## Kurri Kurri Lateral Pipeline Project update

APA Group is pleased to provide an update on the Kurri Kurri Lateral Pipeline Project (KKLP – the Project).

## Attachment 1 – Design refinements

JGN Offtake Facility

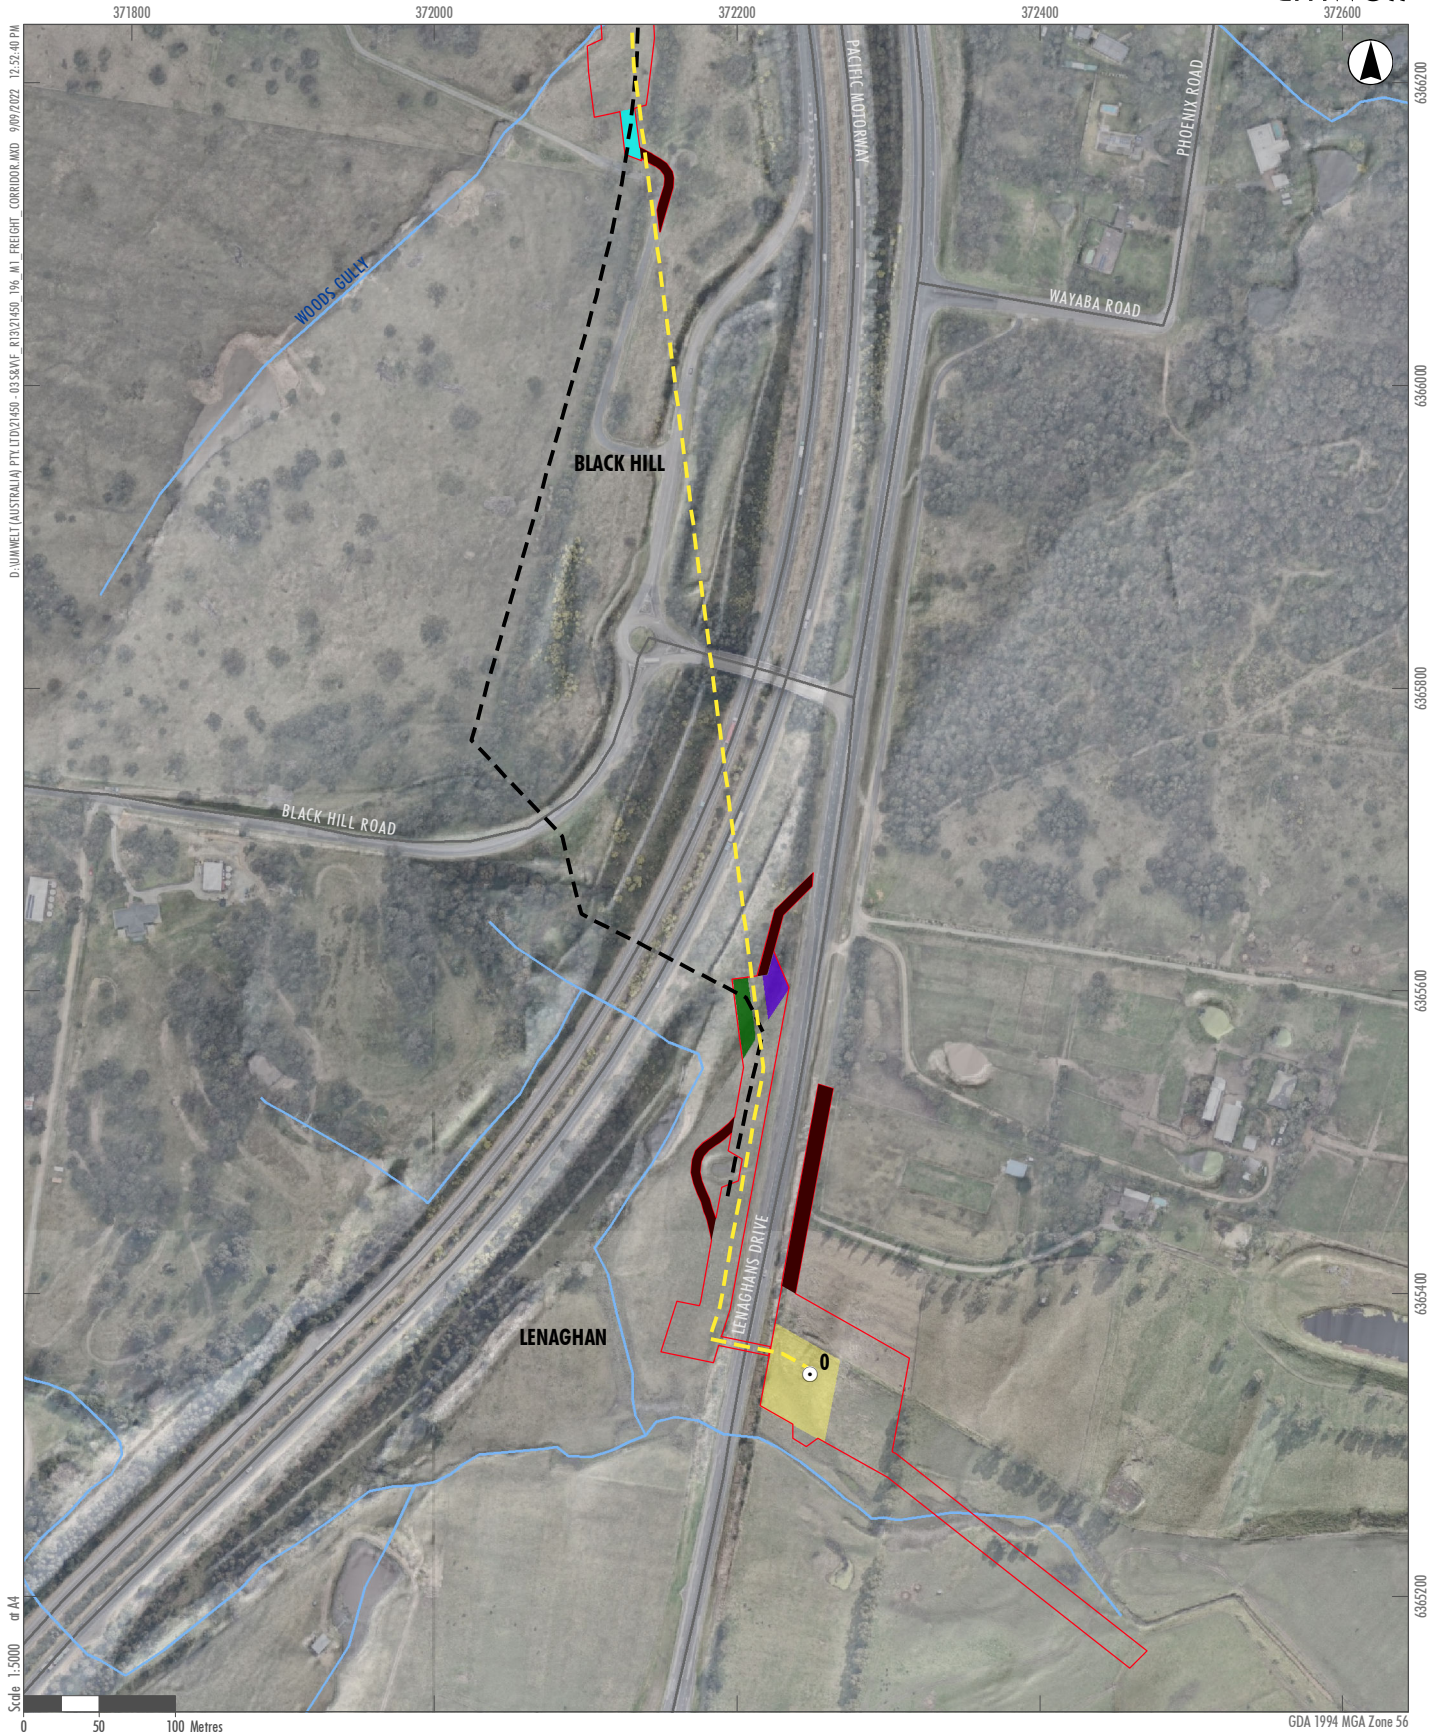
The KKLP EIS presented the JGN offtake facility on the western side of Lenaghans Drive (Lot 51 DP1158920) based on favourable consultation with the landholder. Ongoing negotiations with the landholder have, however, been unable to reach an agreement for locating the offtake facility on this property. As such, discussions with adjacent landholders have been undertaken with a view to locating the offtake facility on a nearby landholding.

APA have subsequently reached in-principle agreement with the landholder on the eastern side of Lenaghans Drive (Lot 453 DP 807778) for locating the JGN offtake facility with the proposed location shown below. This landholding hosts the Sydney to Newcastle Pipeline and remains proposed for the short section of interconnecting pipeline between the SNP and JGN delivery facility.

The proposed location is approximately 70m from the EIS location at its' closest point. Access to the proposed location will be either through the affected landholding or the landholding to the north. Positive discussions have been held with the landholder to the north (Lot 4512 DP573791) and it is likely that the access track will be constructed on this lot.

M1 and Lower Hunter Freight  
Corridor Crossing

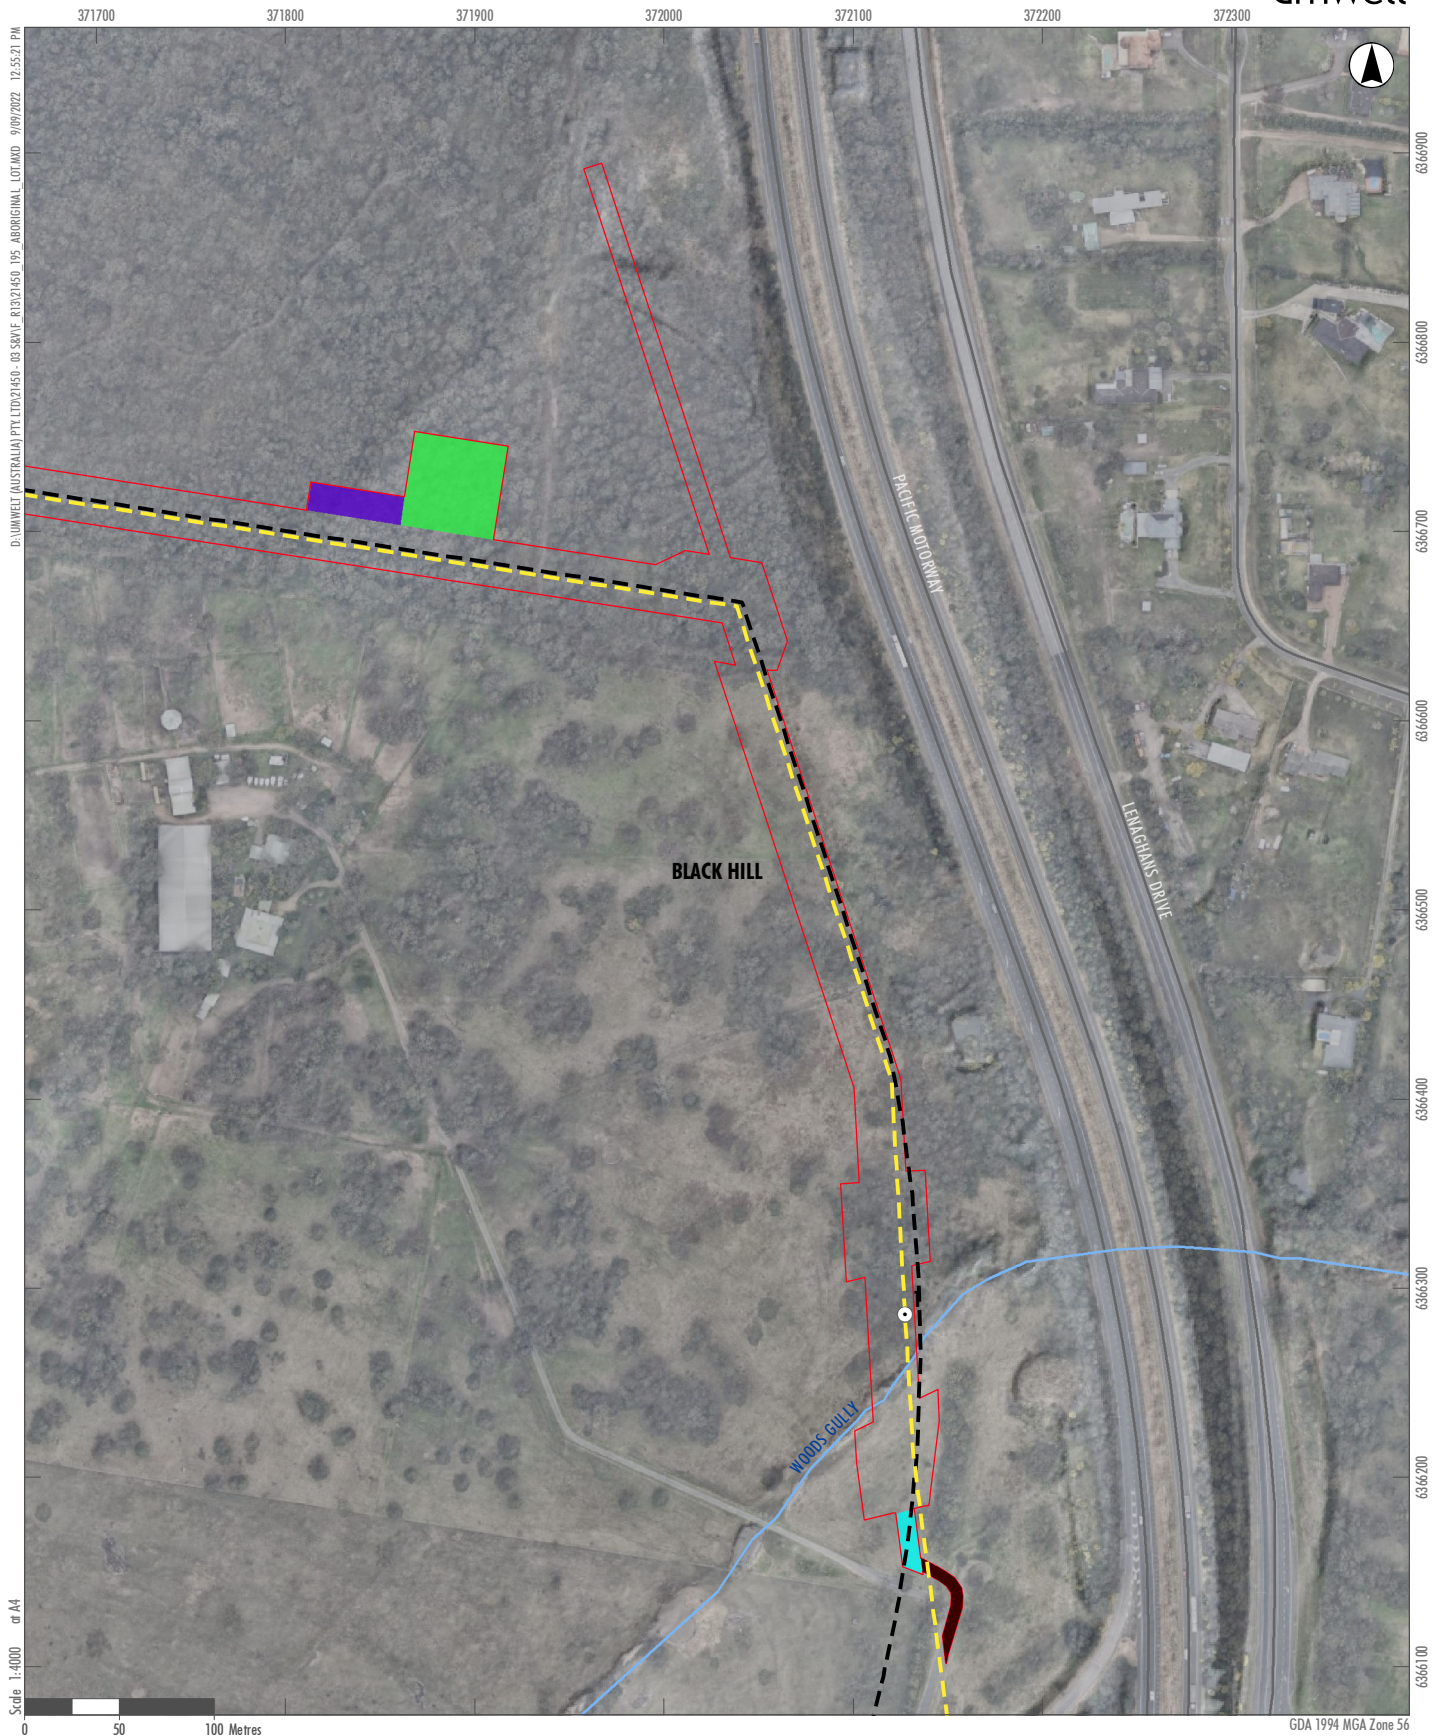
Alignment options for crossing the M1 and Lower Hunter Freight Corridor (LHFC) are described in Section 5.3.1.2 of the EIS. Consultation with TfNSW has been ongoing since EIS submission and in principle agreement has been reached to progress the Option 2 design crossing using a horizontal direction drill (HDD). The environmental impacts of Option 2 are generally reduced relative to the base case alignment presented in the EIS through the use of HDD rather than horizontal boring and open trenching. An assessment of environmental impacts of crossing options are outlined in Section 5.3.1.2 of the EIS.

To the north of the HDD exit point, the construction footprint for the transmission pipeline has been shifted to the west by 5m to avoid all direct impacts to Lot 50 DP881157. This lot is a conservation zone created during construction of the M1 for Aboriginal cultural heritage.

To facilitate the HDD, a stringing area to construct the welded pipeline to be pulled back through the borehole is required. The stringing area is required to be aligned with the HDD angle, and so will extend north from the construction right of way near KP1.2.

**Broaden Management Industrial Estate**

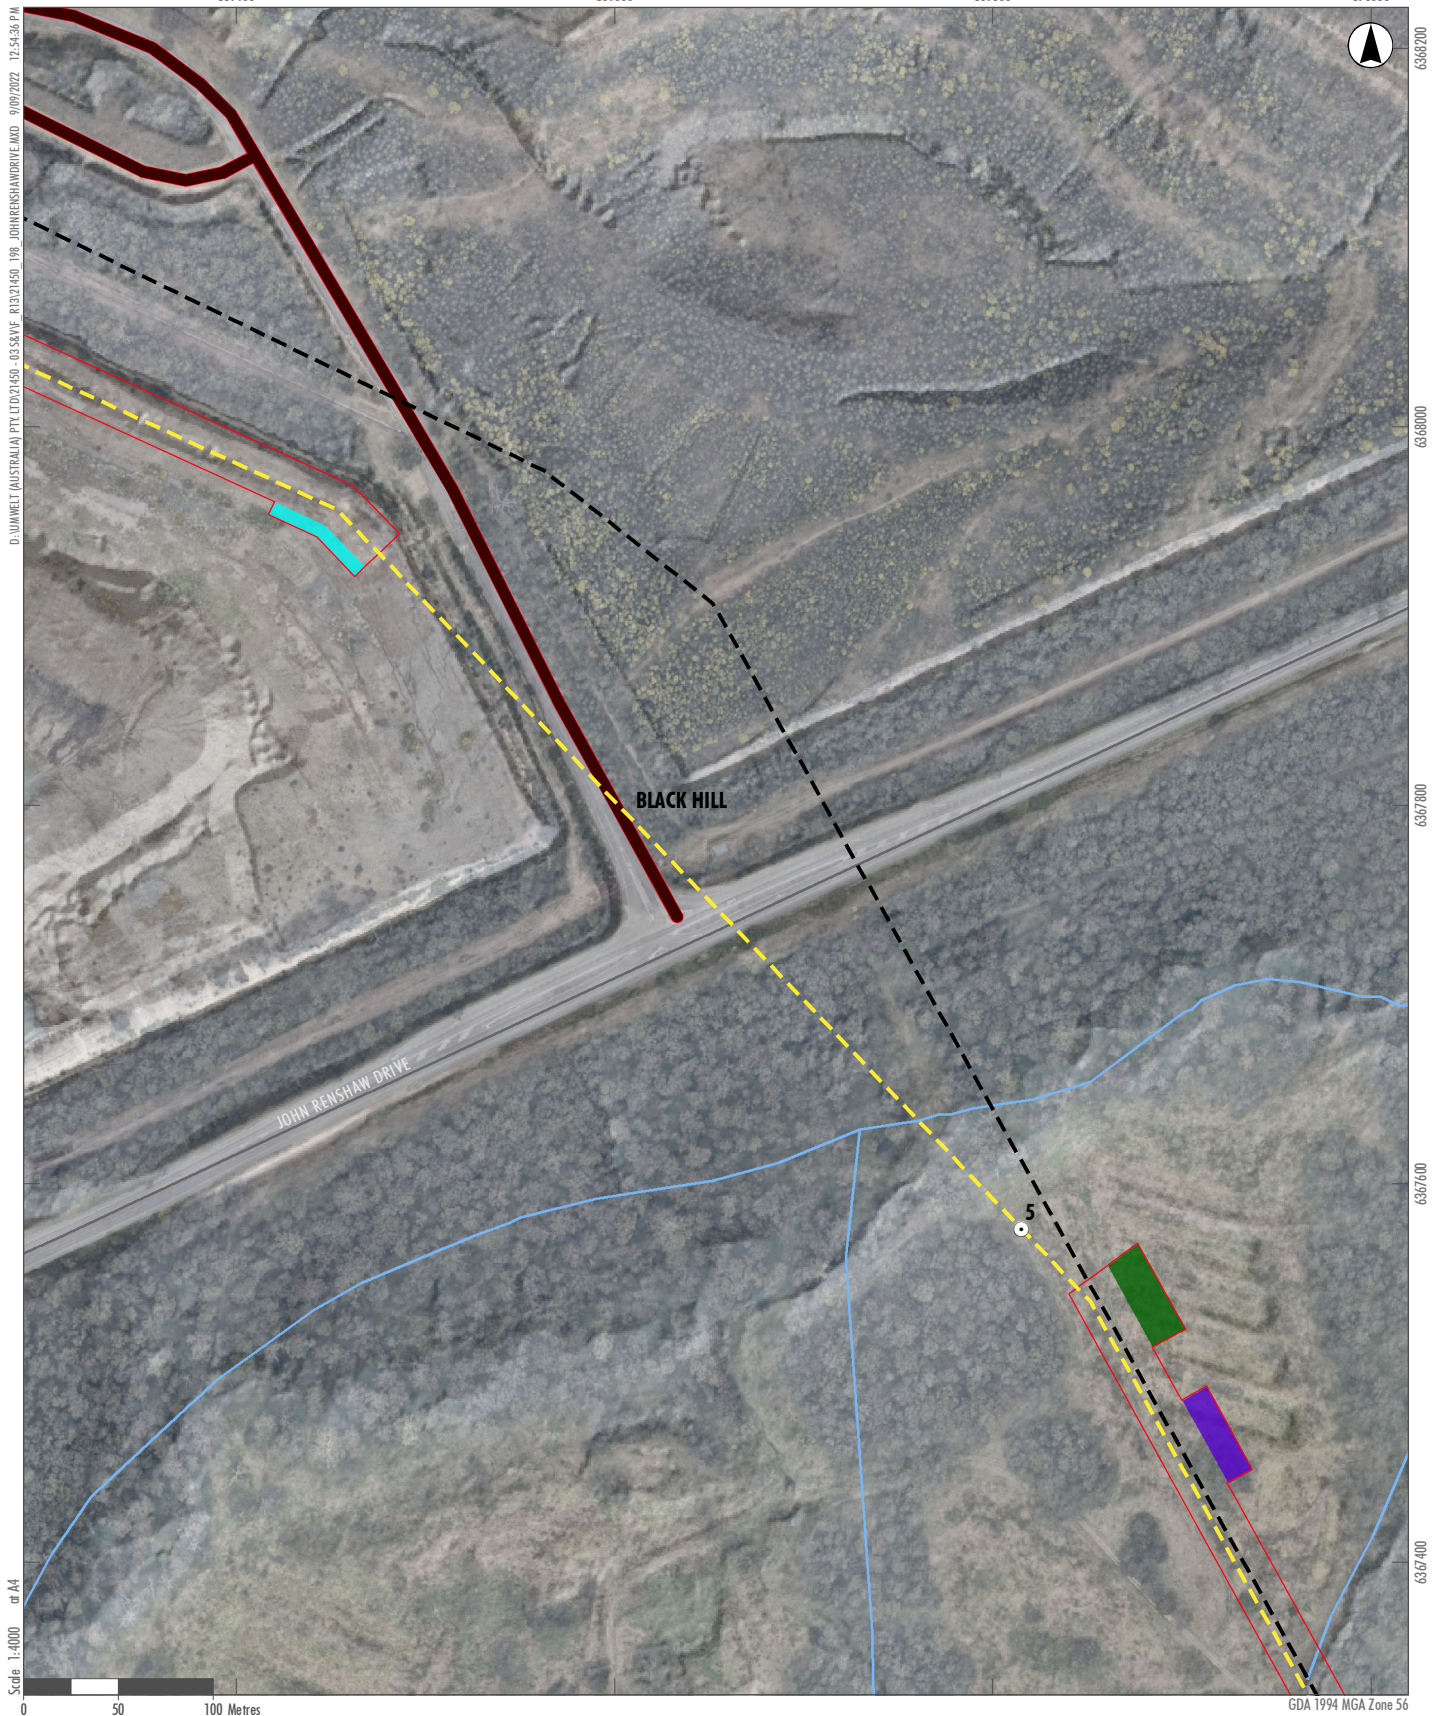
The alignment alternative proposed in Section 5.3.1.2 of the EIS for the Broaden Management Industrial Estate remains under discussion with the landholder and has been conservatively adopted as the worst-case base case for the Amendment Report. This adds around 800m of additional length of the transmission pipeline. Discussions with the landholder regarding use of the alignment presented as the base case in the EIS are ongoing. Both options will be presented in the Amendment Report.

Area north of existing mines  
administration building

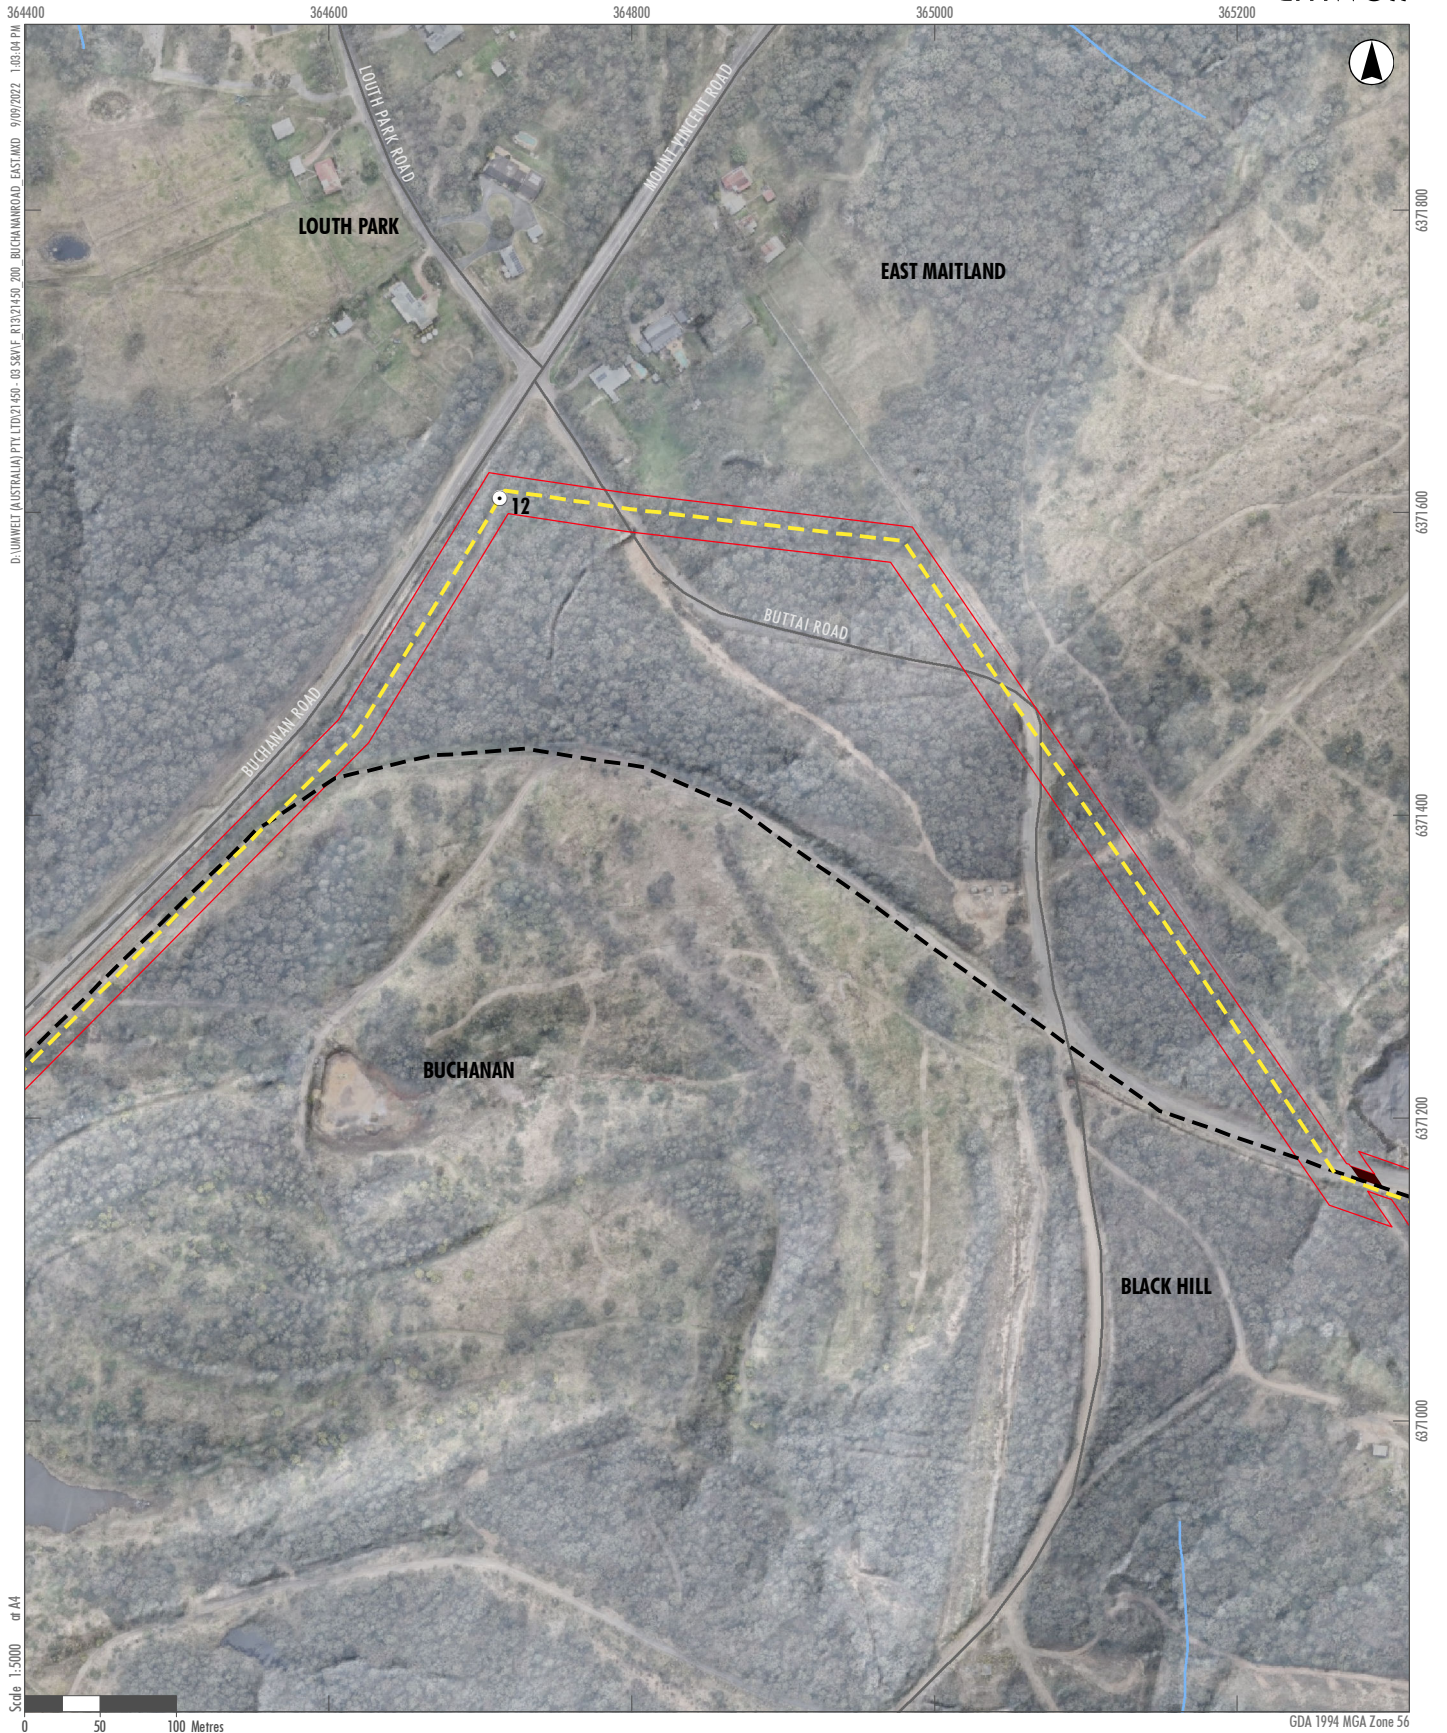
Detailed survey investigations have located numerous buried services (water and telecommunications) within the EIS construction footprint for around 700m north of the existing administration building for the Donaldson and Abel mines. It is proposed to move the construction footprint 25m to the west so that most services are avoided.
